Our Ref : 314995/GH/JR

Proposal Outline planning application for the construction of up to 140,000 sqm of employment floorspace (use class B8) with ancillary offices and facilities and servicing and infrastructure including new site accesses. Internal roads and footpaths, landscaping including earthworks to create development platforms and bunds, drainage features and other associated works including demolition of the existing farmhouse.

Location Land east of Junction J.11, M40, Banbury

Application No. 23/03428/OUT

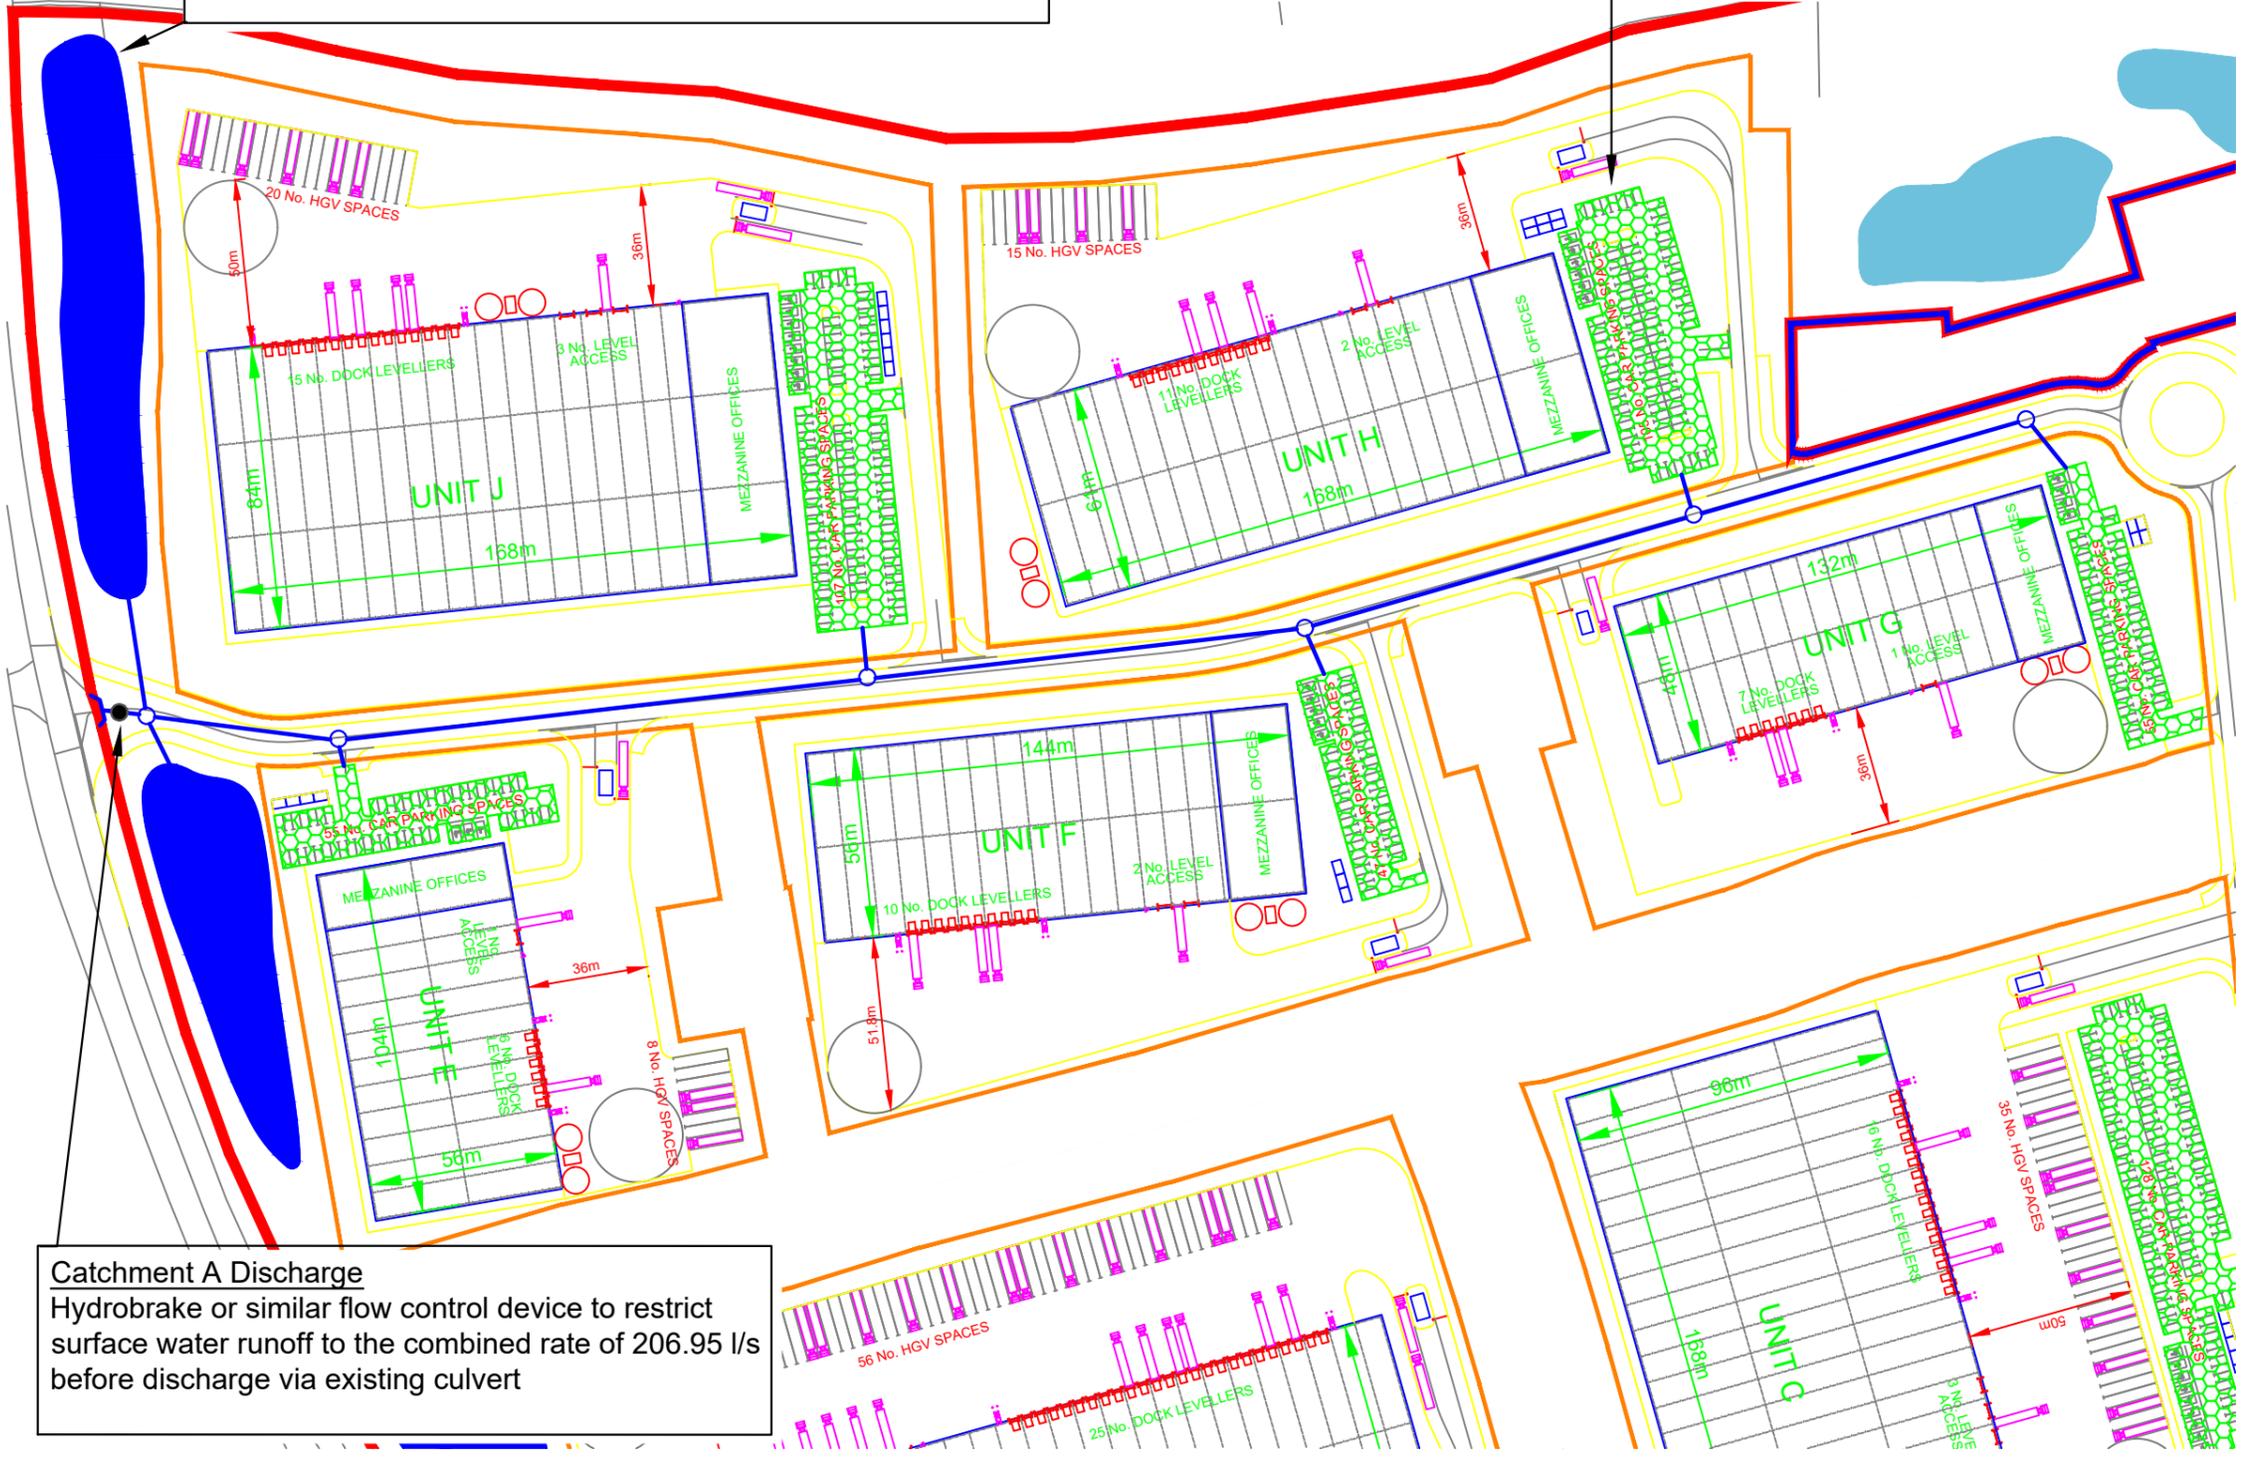
"The FRA explains the surface water drainage strategy however a surface water drainage drawing is required to demonstrate the surface water strategy. Proposed SuDS features and drainage infrastructure needs to be shown indicatively. Outfall locations to be shown, storage details of proposed SuDS features and infiltration rates if applicable".

A Surface Water Drainage Drawing is included in Appendix A of this letter.

As described in the Delta-Simons FRA & DS, surface water runoff will be discharged to the neighbouring site's drainage system and ultimately the River Cherwell via two culverts along the western Site boundary at a combined maximum rate of 460.51 l/s.

Surface water runoff up to the 1 in 100 year plus 40% climate change allowance event will be attenuated on site. A total attenuation volume of 21,526 m³ will be required to achieve the discharge rate and will be provided in the form of ponds, swales or detention basins located in the west of the Site and also within permeable paving.

The Drainage Drawings shows that the require amount of attenuation is available within the car parking areas and the proposed ponds within the north-western extent and within the demise of the southern plots.

Drawing
**Conceptual Drainage Sketch
Catchment B Area**

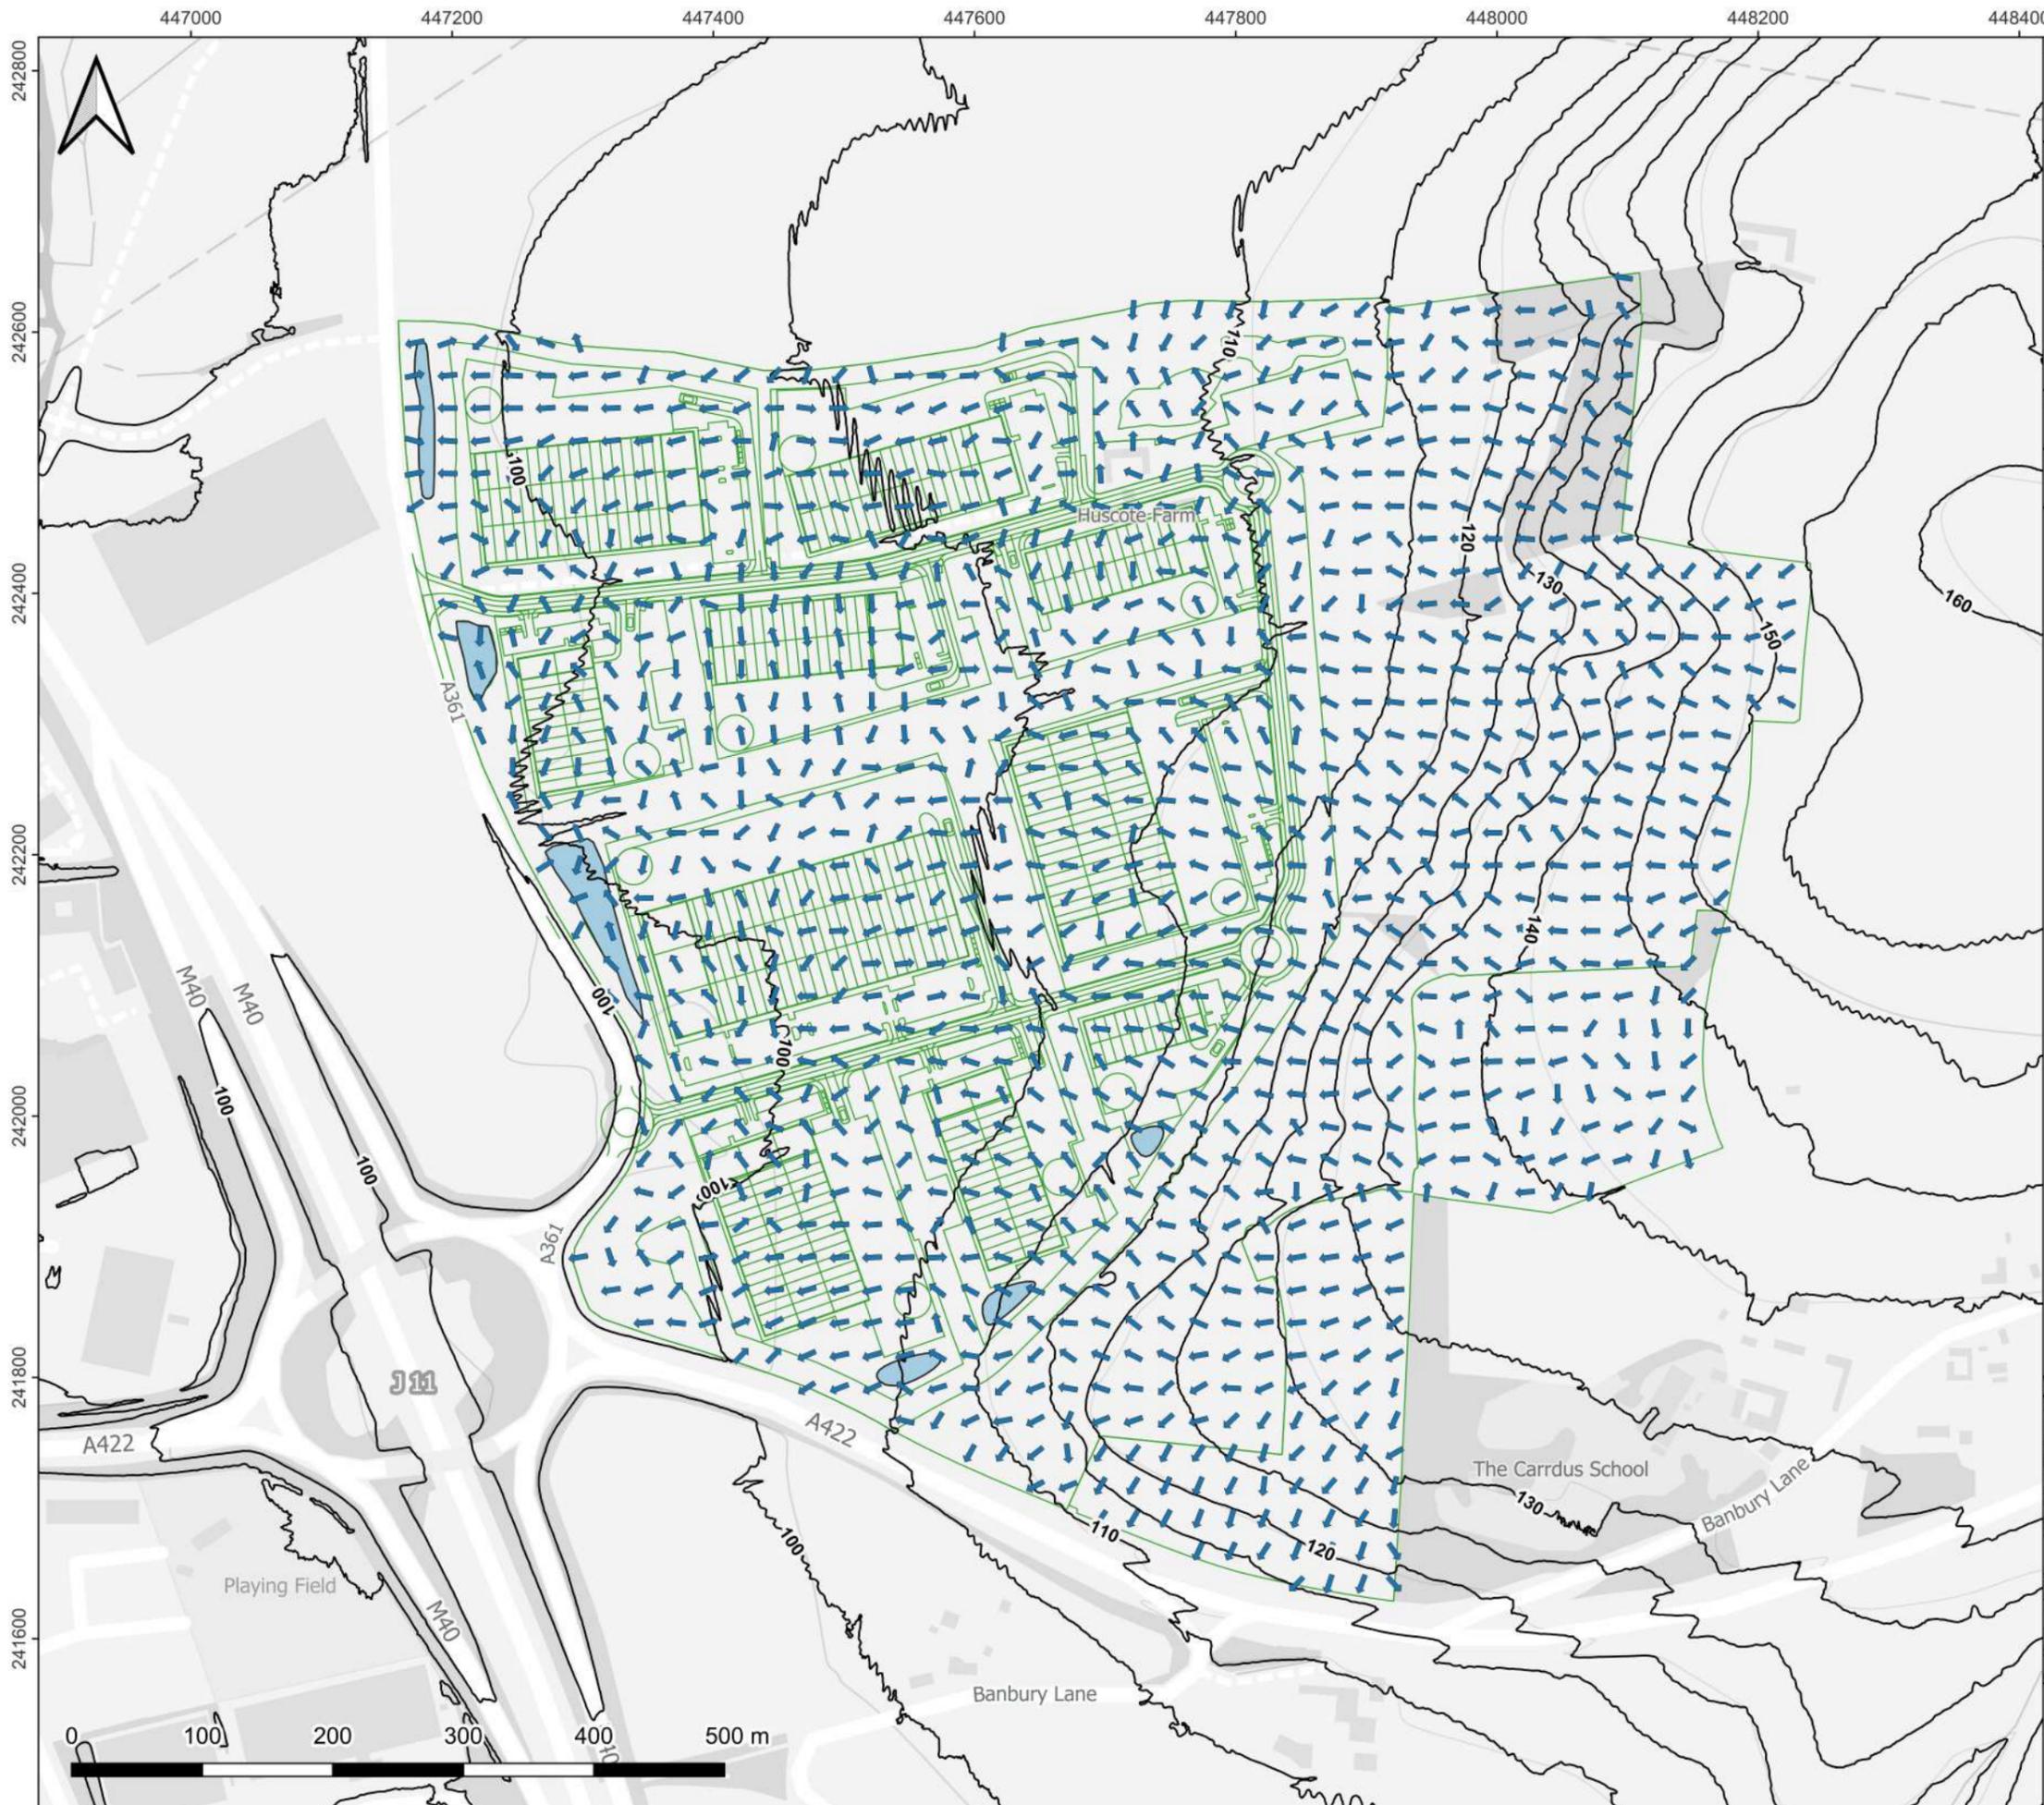
“The catchment areas have been broken down in the FRA, however a Catchment plan is required to highlight the extent of the areas. Stating the total impermeable area and the impermeable area including urban creep”.

A Catchment Plan is included in Appendix B of this letter.

The site can be split into two catchments each served by the two existing culverts at the lowest extents of the site. The site can be further split into individual plot catchments at the detailed design stage if required. It is reiterated that the layout is not fixed, and the catchment areas may change as a result of works undertaken at the detailed stage.

Area (m ²)	Discharge Rate (l/s)
Catchment A	143,060	206.9
Catchment B	175,287	253.56
